WEST SUSSEX COUNTY COUNCIL CONSULTATION

TO:	Arun District Council FAO: James Cross
FROM:	Stephen Gee WSCC - Highways Authority
DATE:	05 January 2021
LOCATION:	Boweries Barnham Road Chichester PO20 3RT
SUBJECT:	BN/135/20/PL Construction of 30 no. dwellings, new access, public open space, landscaping and associated works (submission following EG/22/19/OUT). This site is a Strategic Site in SP2 (Zero Rated).
DATE OF SITE VISIT:	n/a
RECOMMENDATION:	More Information
S106 CONTRIBUTION TOTAL:	TBC

Access Junction Tracking

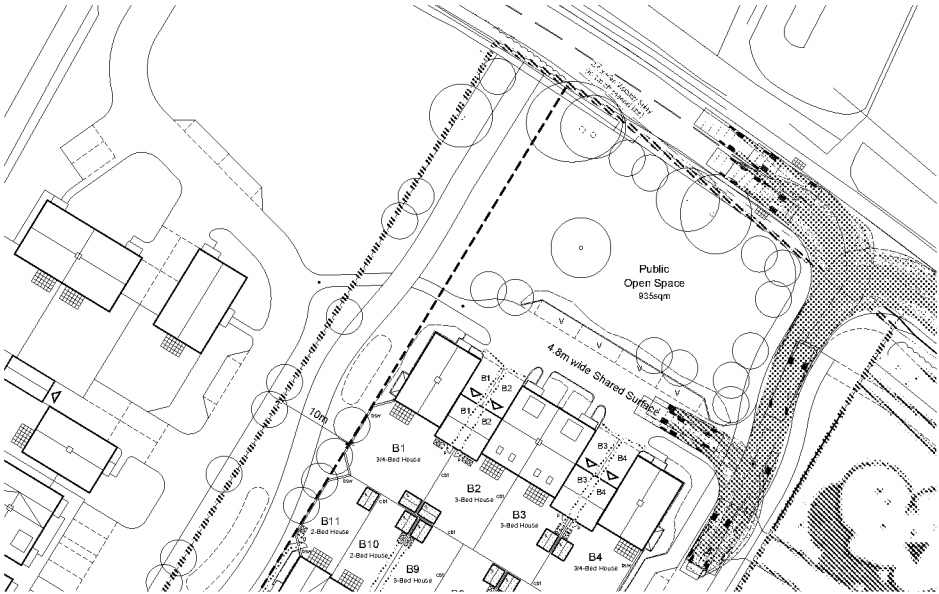
The vehicle tracking of a refuse vehicle raises concern with a significant over running of the centre line and running carriageway

Refuse Vehicle Tracking Within Site

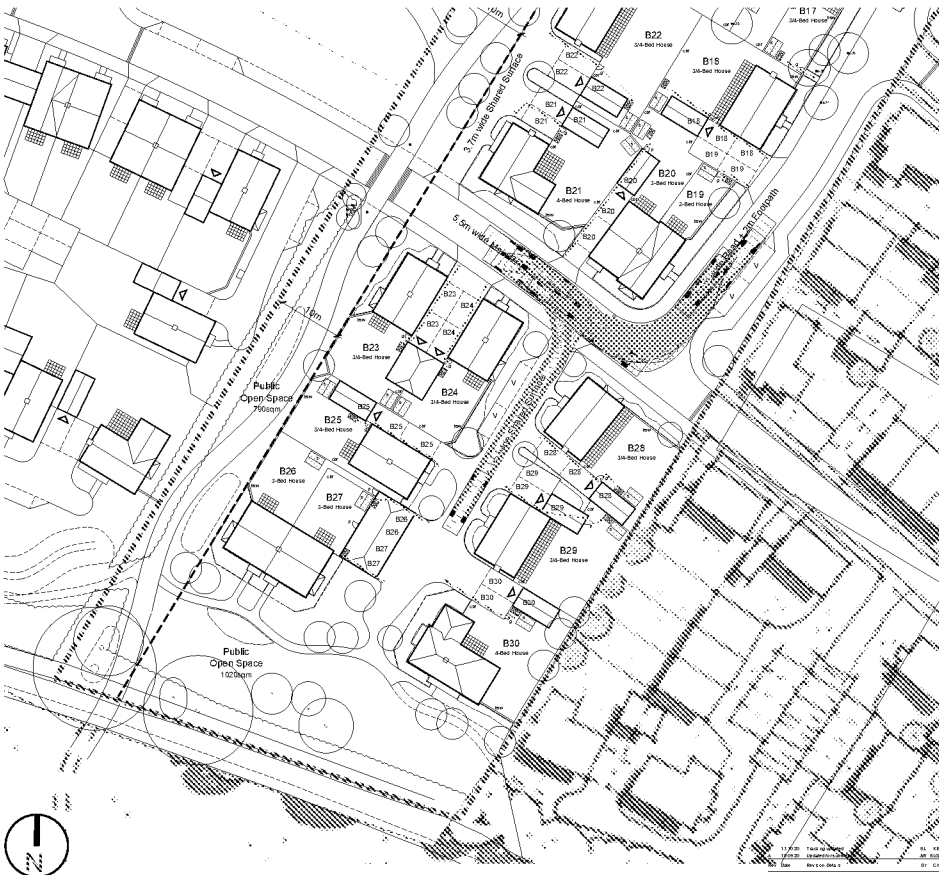
Vehicle tracking has been provided for a refuse vehicle and shows a refuse vehicle could serve the internal elements of the site.
